Wee Hur Student Housing - 104-116 Regent Street, Redfern –GANSW review of the EIS – 22.02.22

1 Level 1 (Ground)
Floor Plan
1 : 200

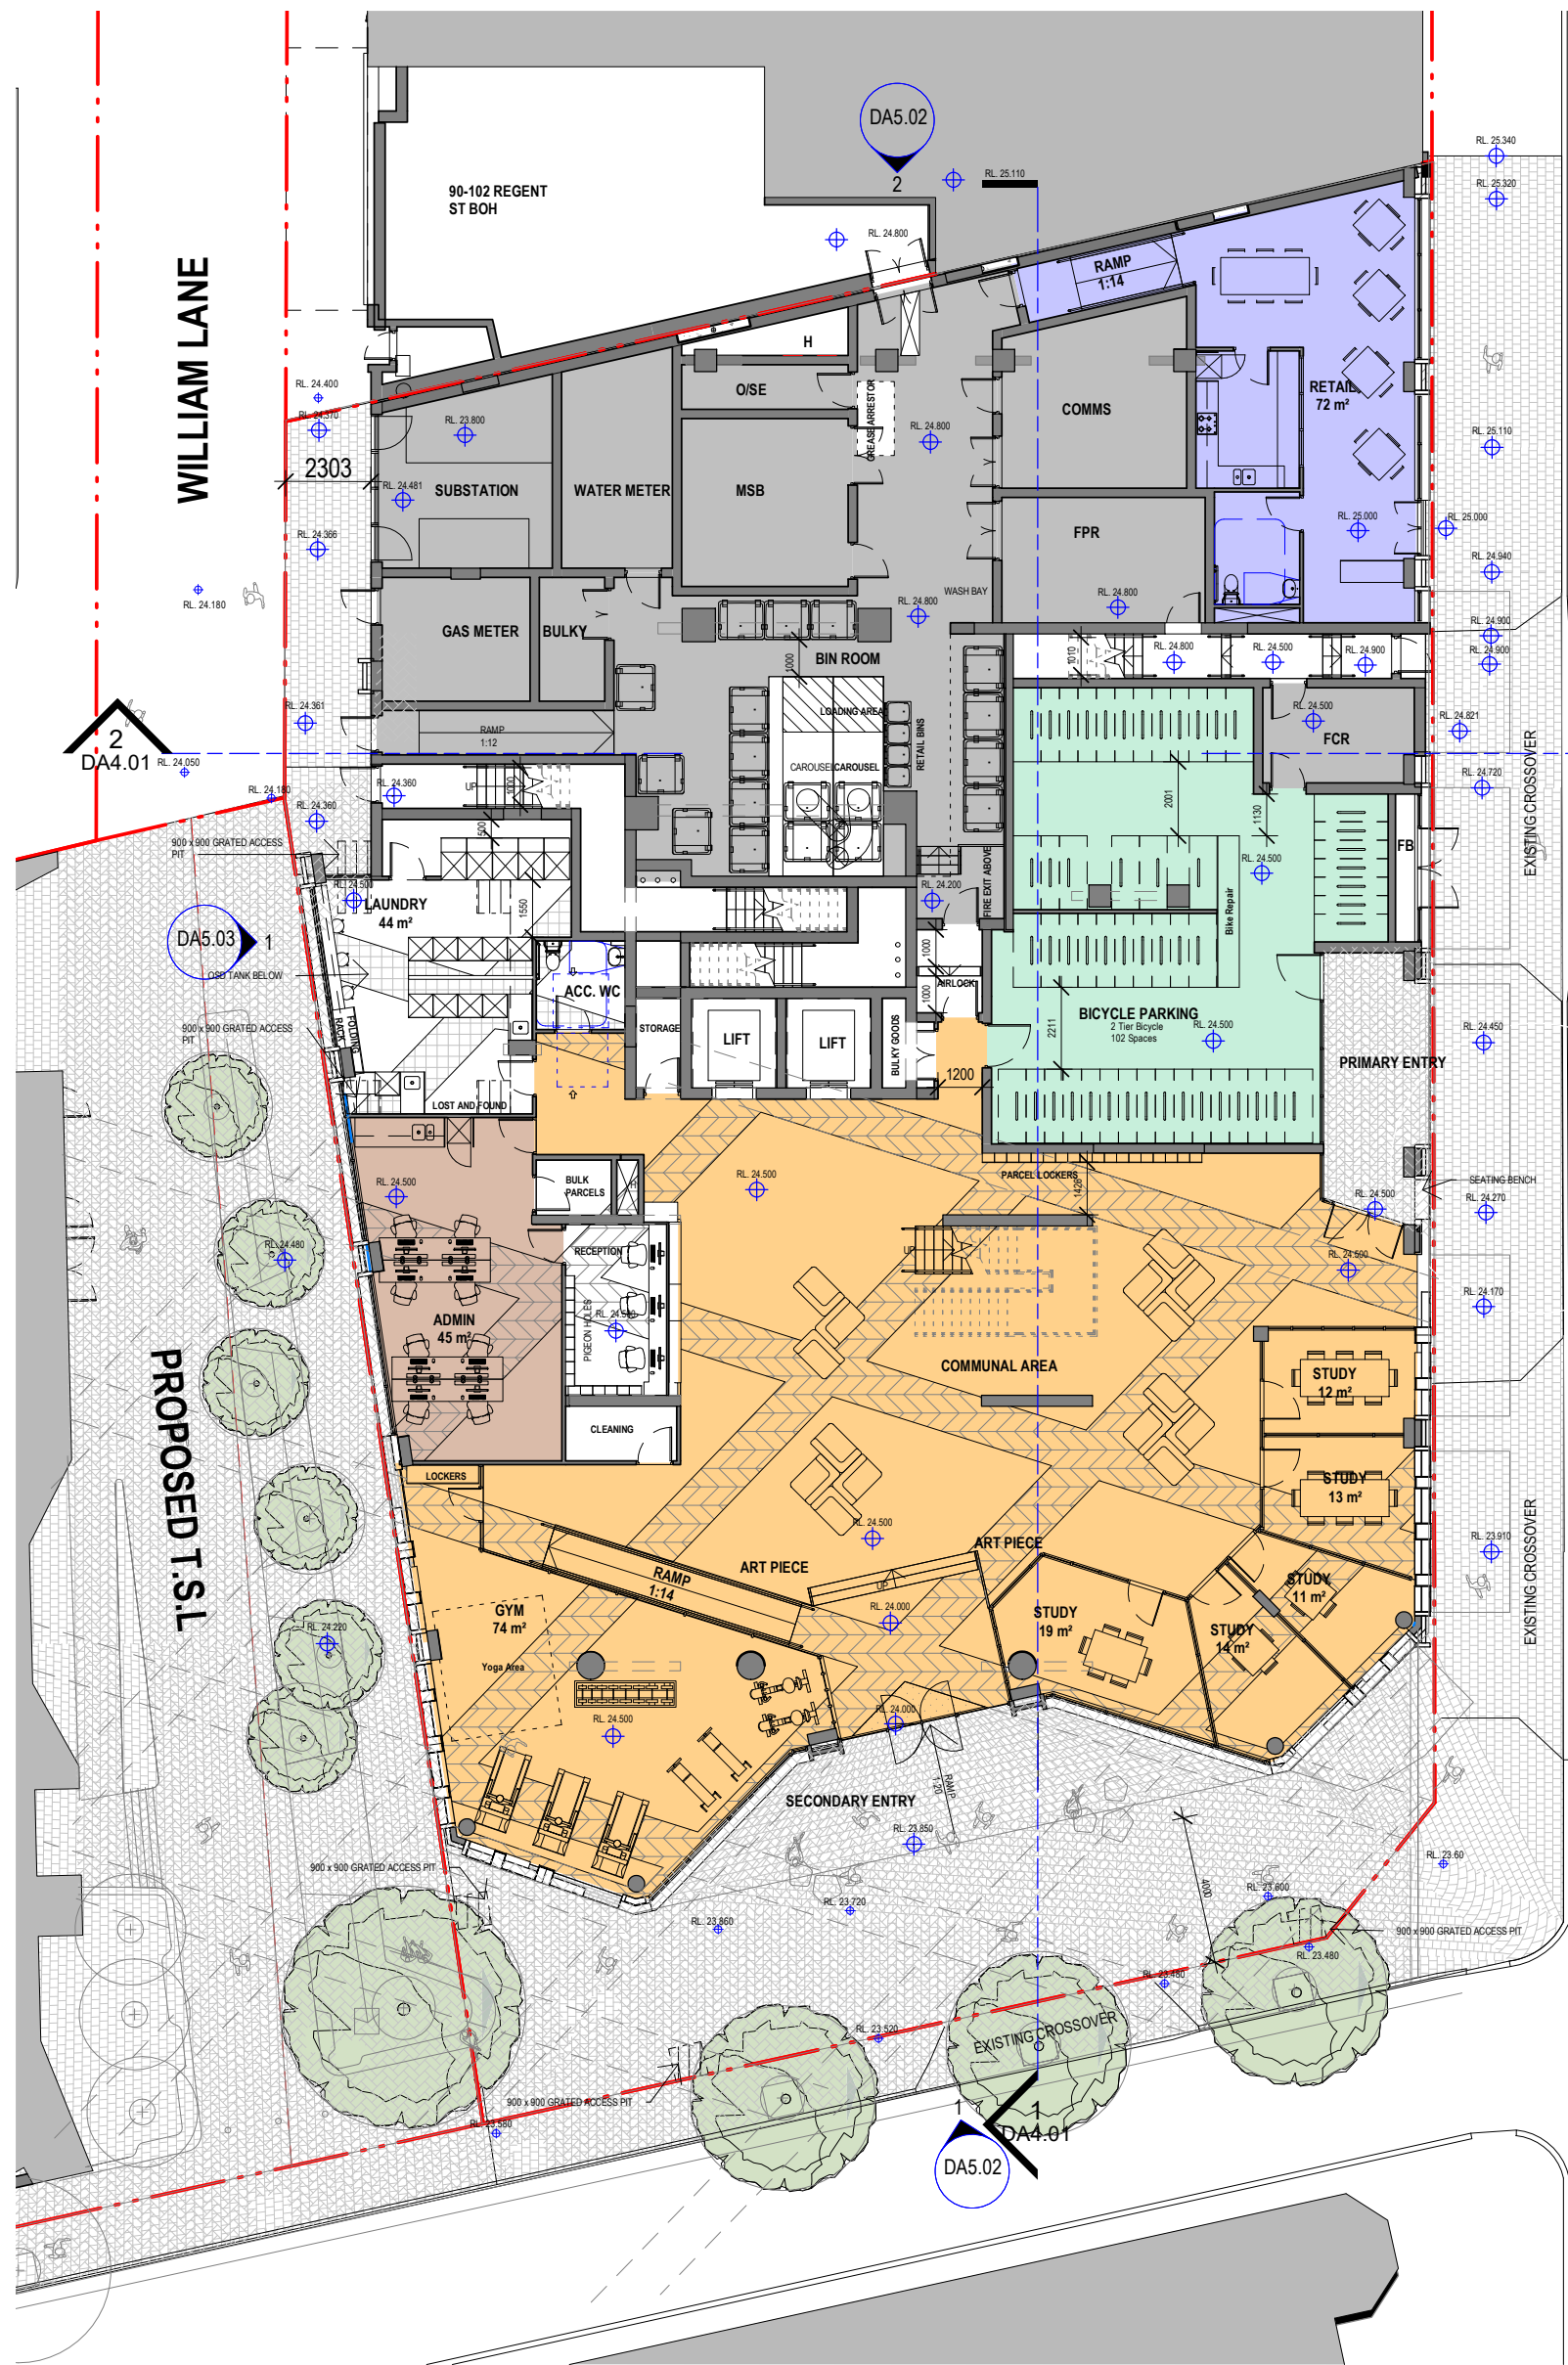
- relocate plant and risers to provide windows immediately adjacent to the lift lobby/waiting areas and
 - take opportunities for corridor windows at upper levels (L16) that are impeded by services cupboards
 - b. It is recommended to provide visual connections between the bike store and the ground floor communal space; noting that shared facilities are often spaces where users may feel '*at risk*'. For example, a visual connections from the service desk/ reception and from the entrance areas of the communal space.
 - c. The long-term flexibility of the ground floor communal space can be improved with greater consideration for the location of services and the accessible ramp.
11. Consider opportunities for shading at rooftop terraces
